MORNINGTHORPE AND FRITTON PARISH COUNCIL

East Pye Solar – EN0110014***Summary of MFPC Written Statement and Response to OFH2 Action Point*****Status and purpose of this summary**

Revision A

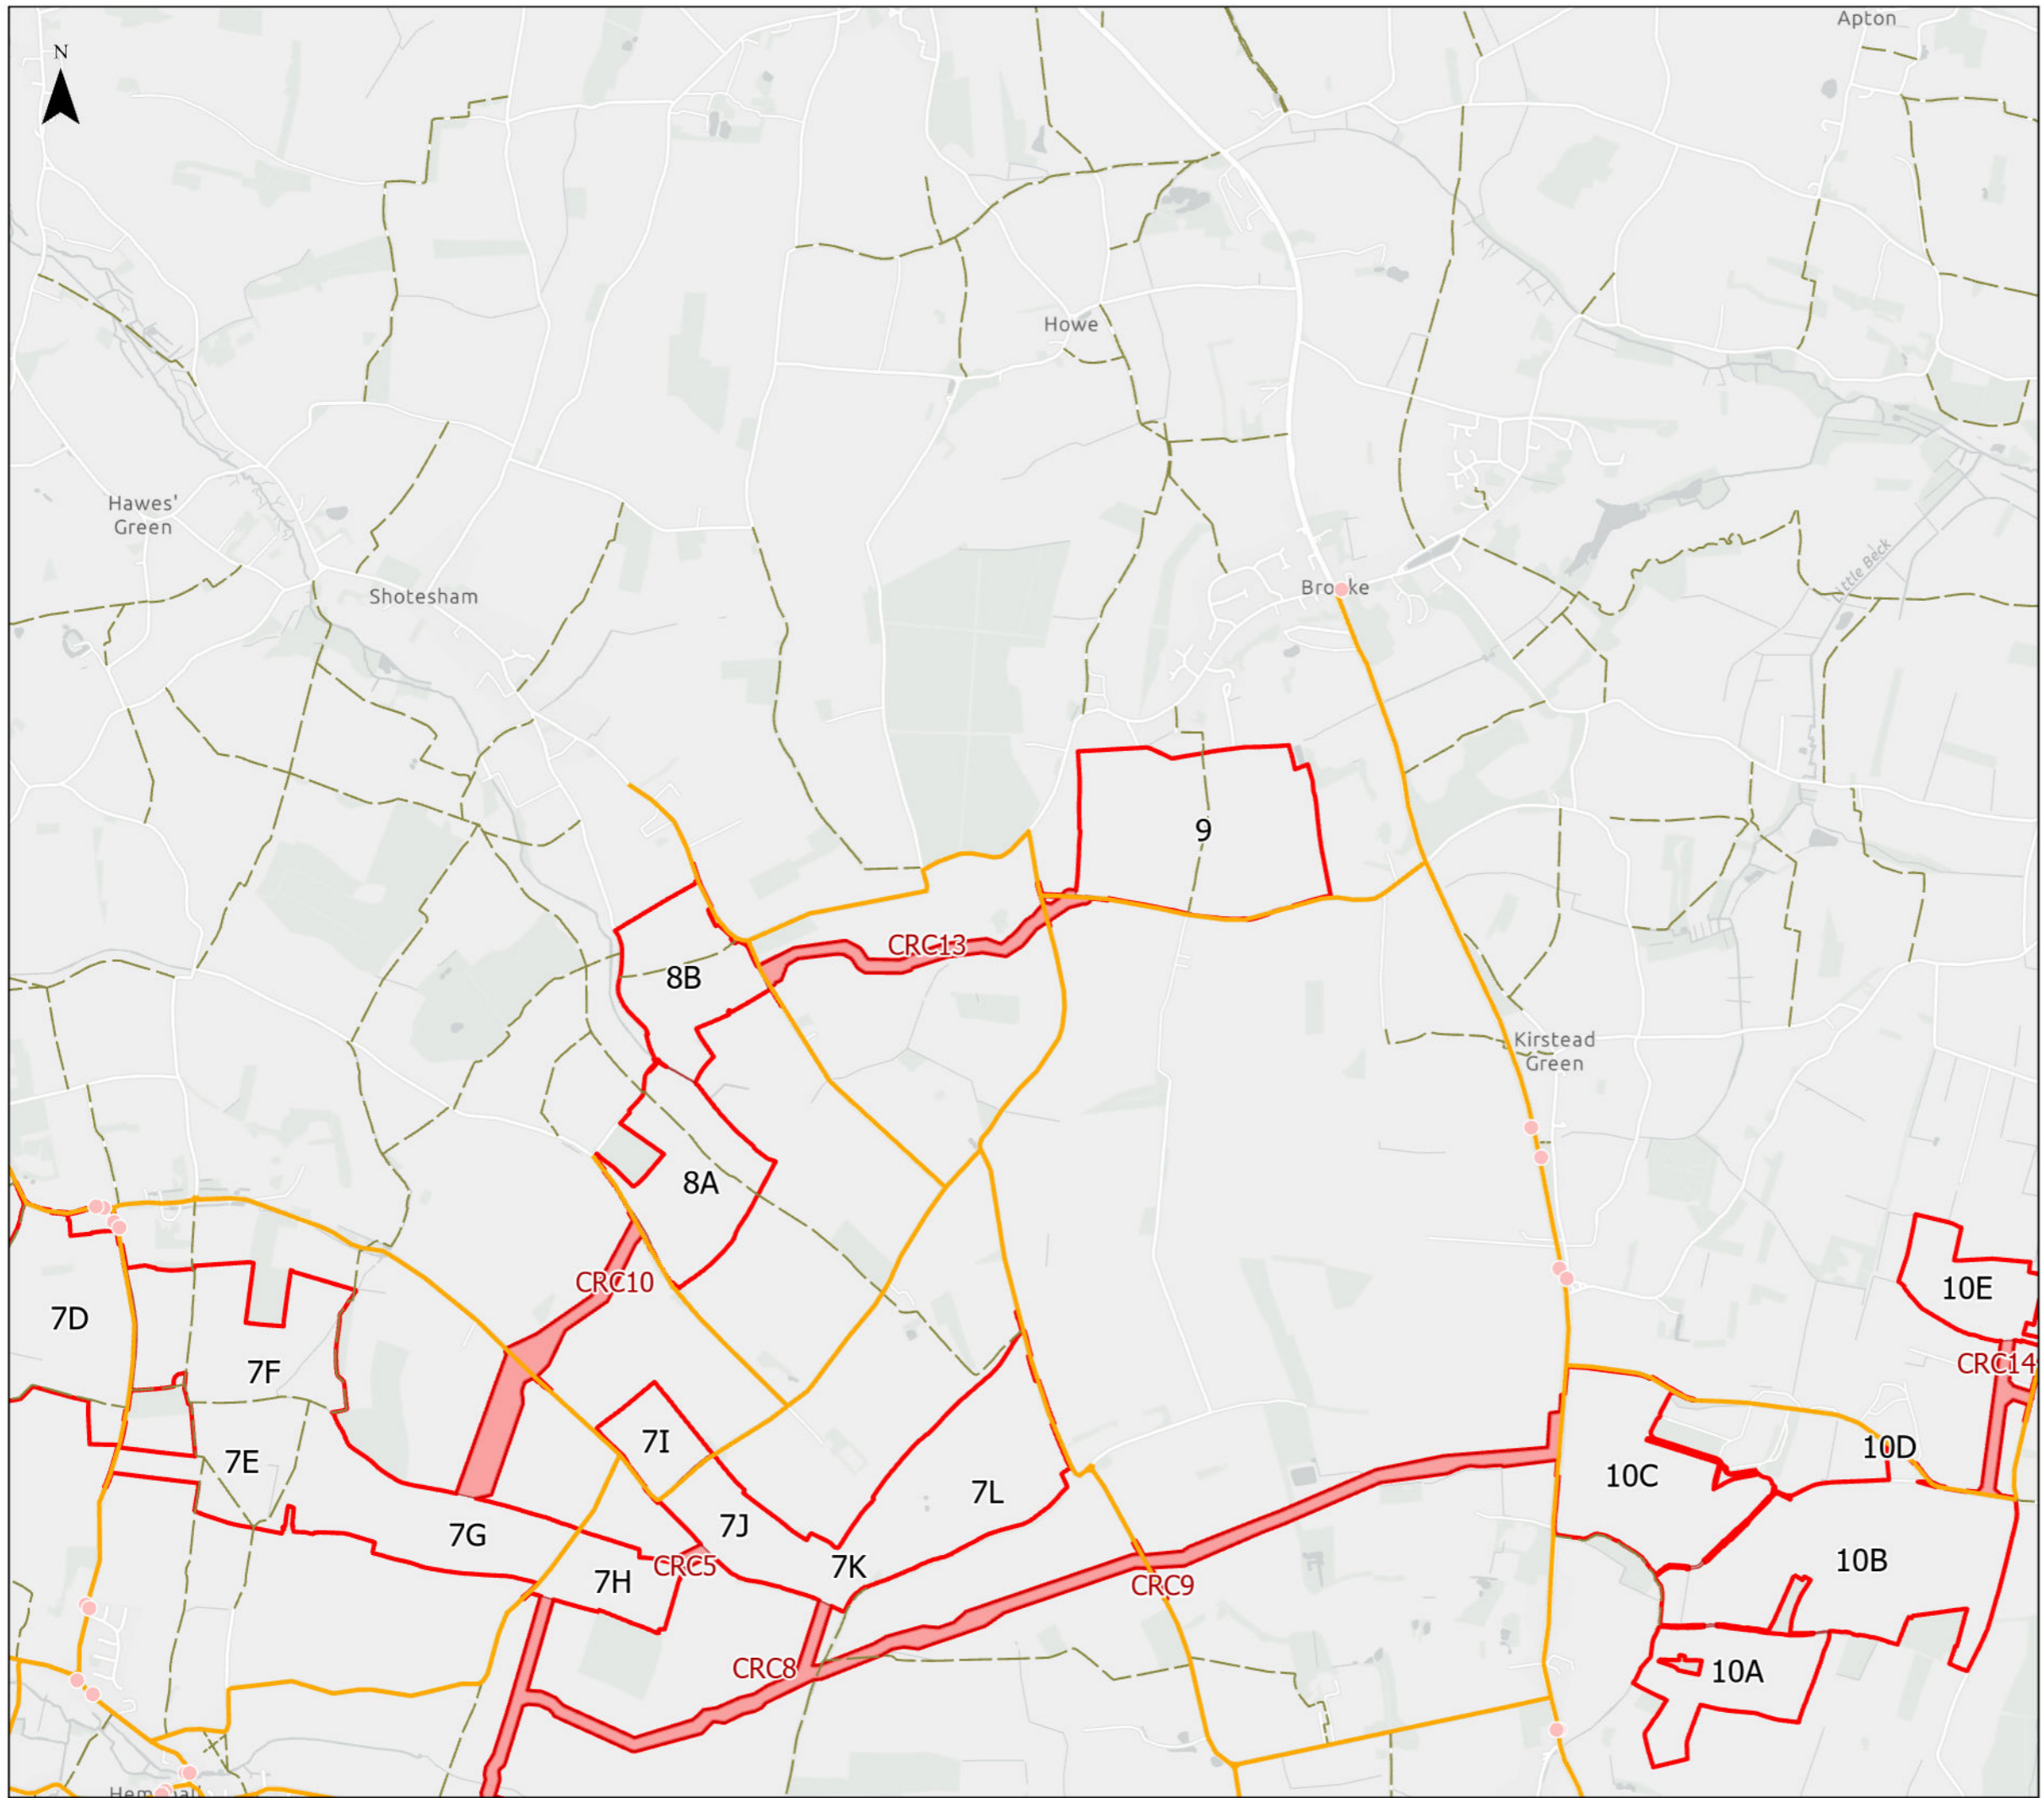
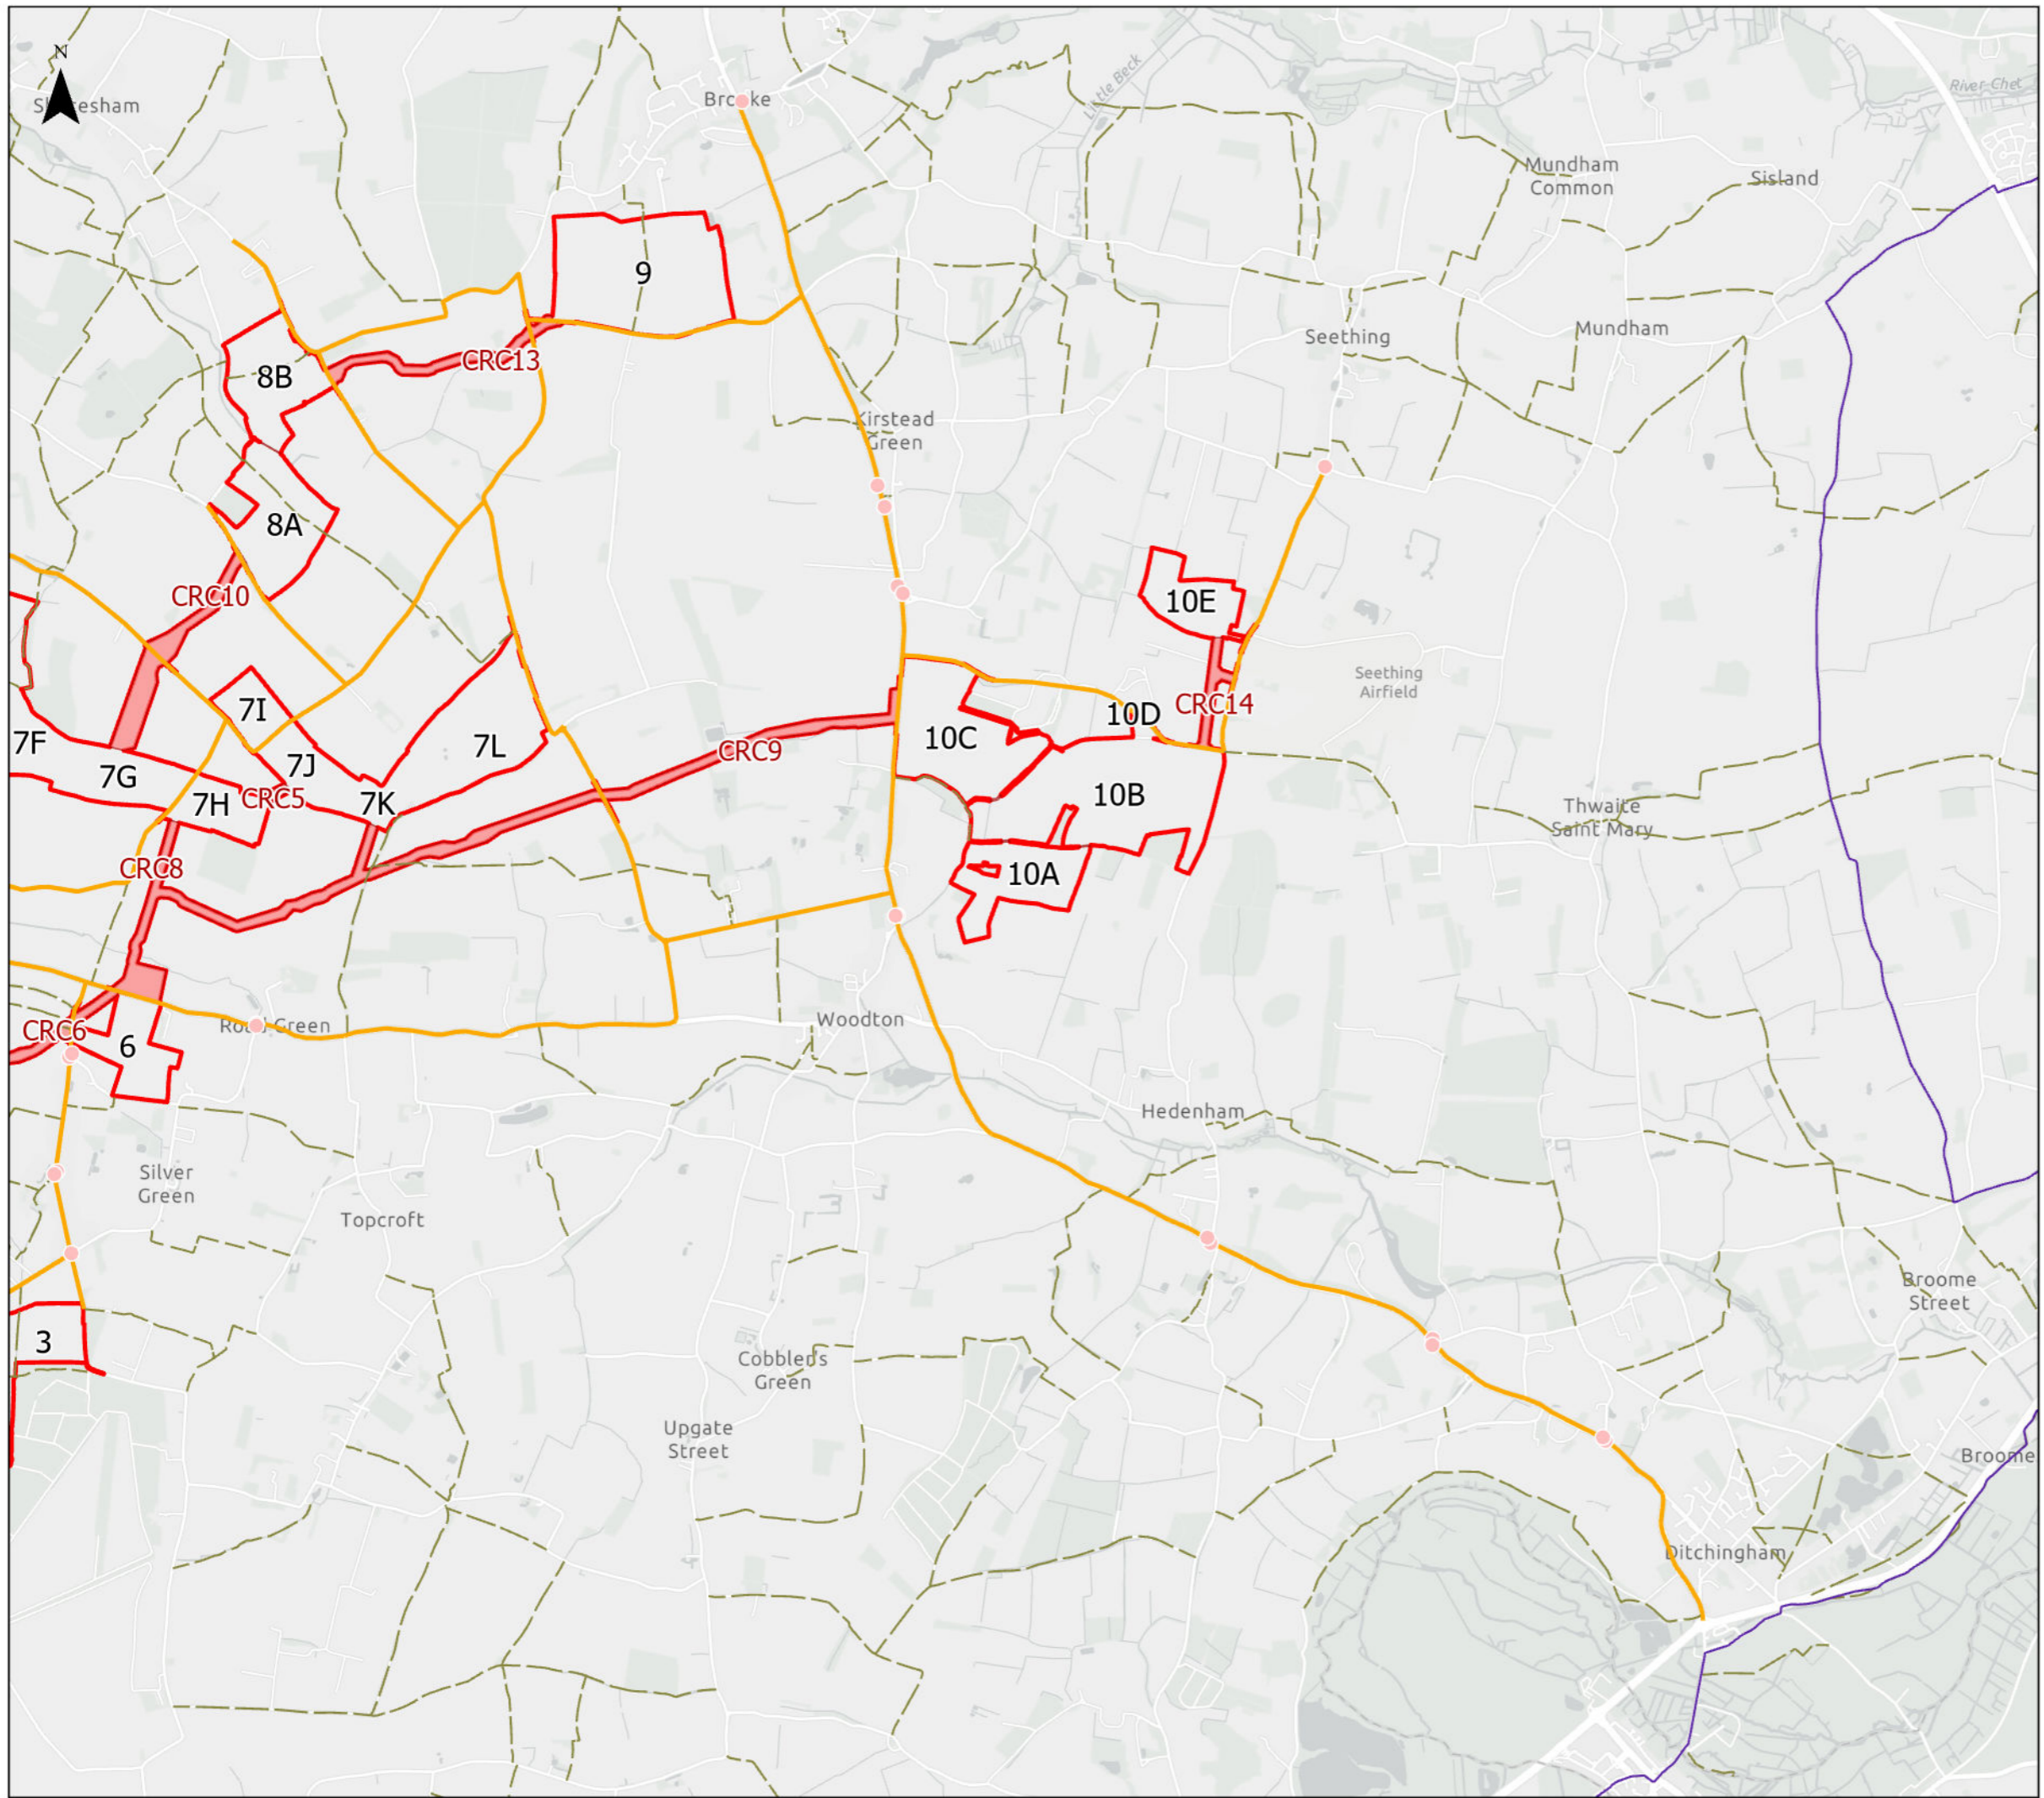
The Public Rights of Way are important to MFPC not simply as transport routes but because of the experience they provide: tranquillity, open views, wildlife, heritage and connection between settlements. Temporary closure or eventual reopening does not by itself preserve that experience. Appendix 1, pp.304–348, documents a footpath journey through and around Site 5 to support this point. Appendix 3, pp.388–396, similarly records the driven experience and views of Site 5 from surrounding roads, including the B1527.
